Application Ref:	3/2021/0213	 <div>Ribble Valley Borough Council</div> <div>www.ribblevalley.gov.uk</div>	
Date Inspected:	4/3/2021		
Officer:	BT		
DELEGATED ITEM FILE REPORT:		Decision	Approval

Development Description:	Regularisation and alteration of unauthorised paved patio area on multiple levels to the front of the house and insertion of patio door to front elevation.
Site Address/Location:	18 Bryers Croft, Wilpshire. BB1 9JE

Plan title: PROPOSED PATIO

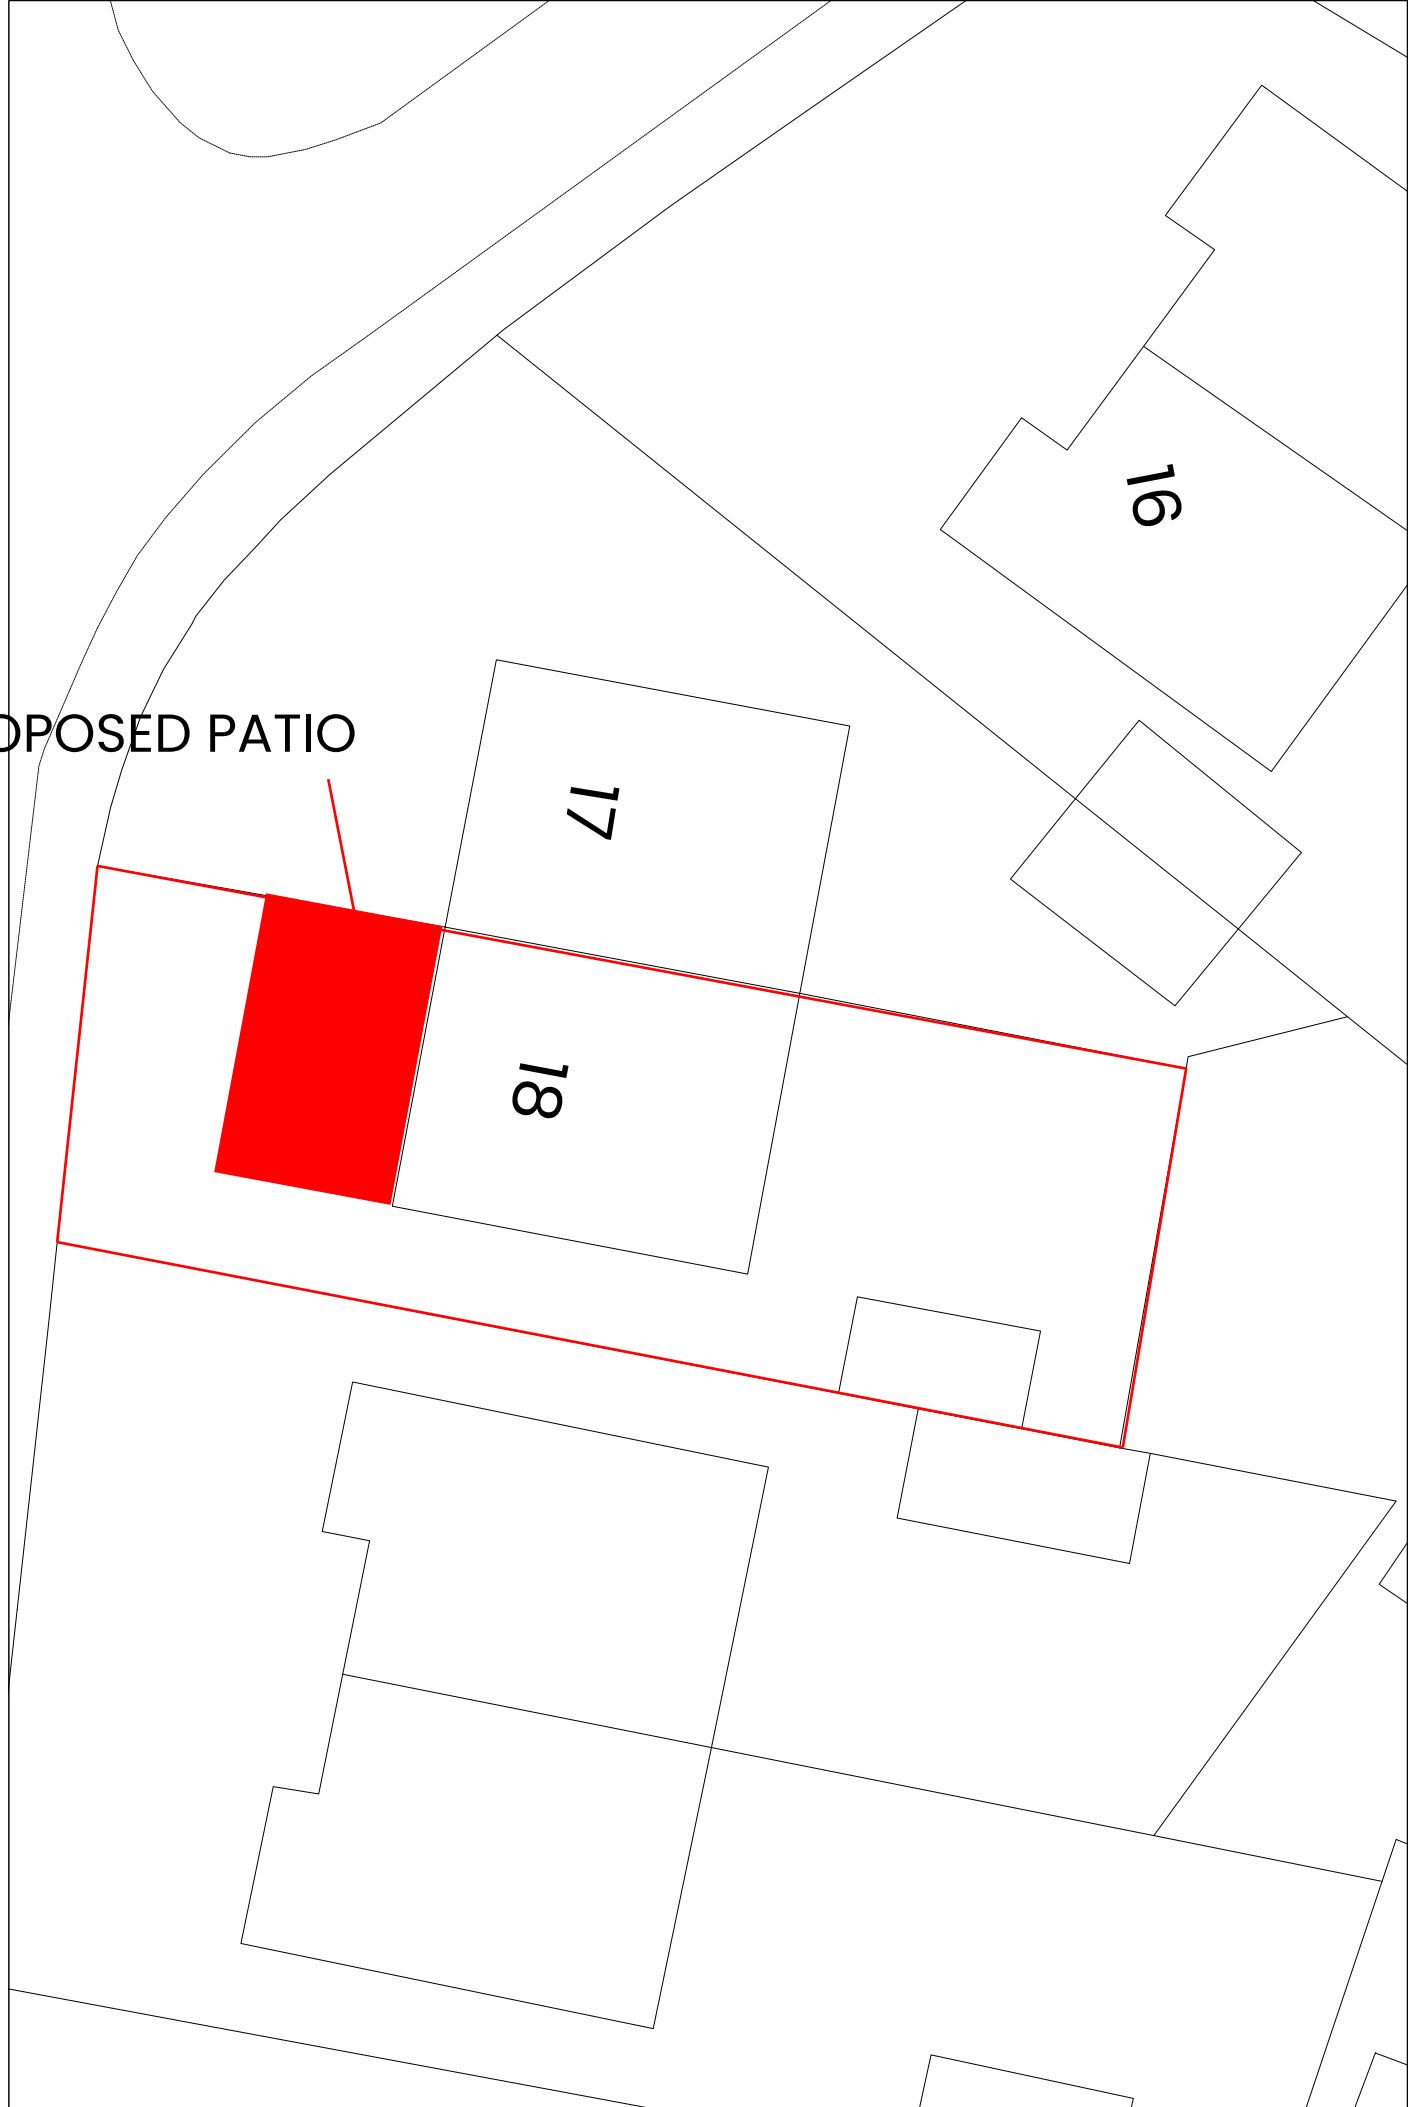
The proposal will restore the current patio to a three tier design which will be largely reminiscent of the original patio structure. The highest tier will stand 2.1 metres above ground floor level and will measure 6.5 x 2.0 metres. The second tier will be stepped down by 0.5 metres and will measure 6.5 x 2.3 metres while the third tier will be stepped down by a further 0.2 metres and will cover a considerably smaller area of 6.5 x 0.8 metres. The property's front lawn area will remain in the area between the patio and the pavement 0.7 metres below the third tier of the proposed patio.

HEIGHTS & LEVELS ON
②

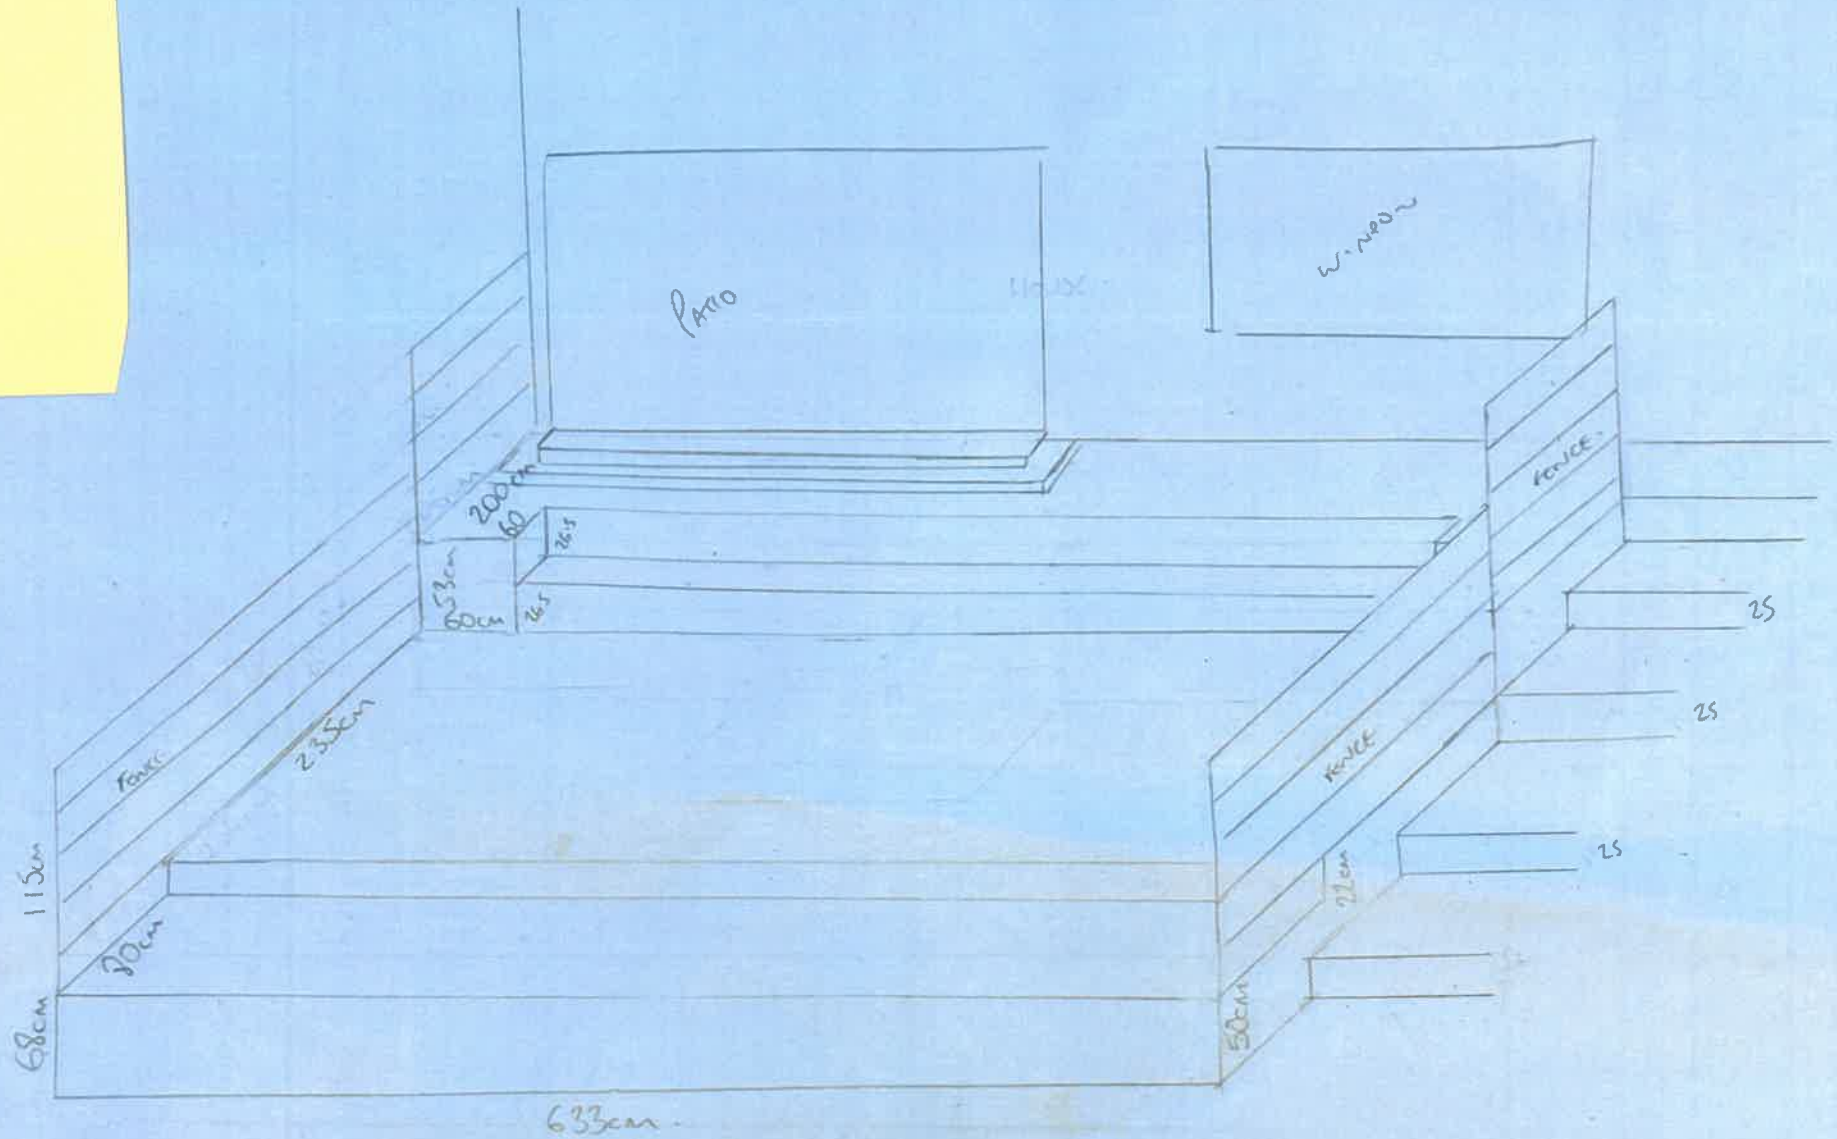
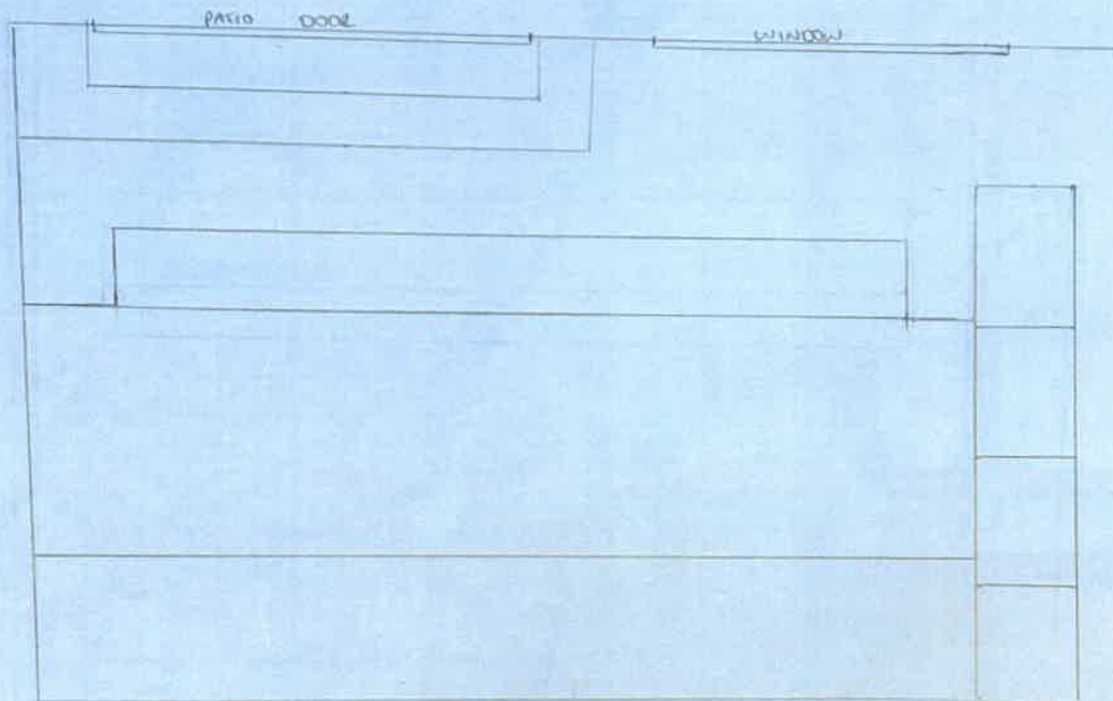
The highest tier of the proposed patio will stand at 2.1 metres above ground level which in turn will allow a certain amount of overlooking towards the front elevations of No. 4, 5 and 6 Bryers Croft which are situated approximately 20 metres away on the opposite side of the road. The patio will also allow partial views into the front curtilage of the adjoined property of No. 17 Bryers Croft by virtue of its elevated position.

Concerns have been raised during the consultation process with regards to loss of privacy through overlooking from the proposed patio however it is worth noting that each of the tiers on the proposed patio structure will be stepped down incrementally in terms of height and that no part of the proposed patio will exceed the height of the current patio structure or the highest part of the original patio structure.

The Northern and Southern edges of the proposed patio are to contain slatted timber fencing which will be stepped down in accordance with each of the patio's tiers in an almost identical manner to the previous brick panel fence that was situated on the boundary between No. 17 and 18 Bryers Croft.

None of the slatted fence panels will exceed the previous brick fence panels in terms of height and the applicant has purposely chosen to use slatted fencing in order to maintain the natural light that was received

The unauthorised works to the original patio structure involved the infilling of the patio's lower tiers to form a single raised platform which currently projects outwards from the height of the patio's highest tier at 2.1 metres above ground level to the edge of the property's front lawn area.

Concerns have been raised during the consultation period with regards to the visual impact of the proposed works however it is considered that the proposed alterations outlined above will drastically reduce the cubic volume of the current patio which is essentially an oversized raised platform by roughly fifty percent which in turn will significantly reduce the adverse visual impact of the current patio structure to an acceptable degree.
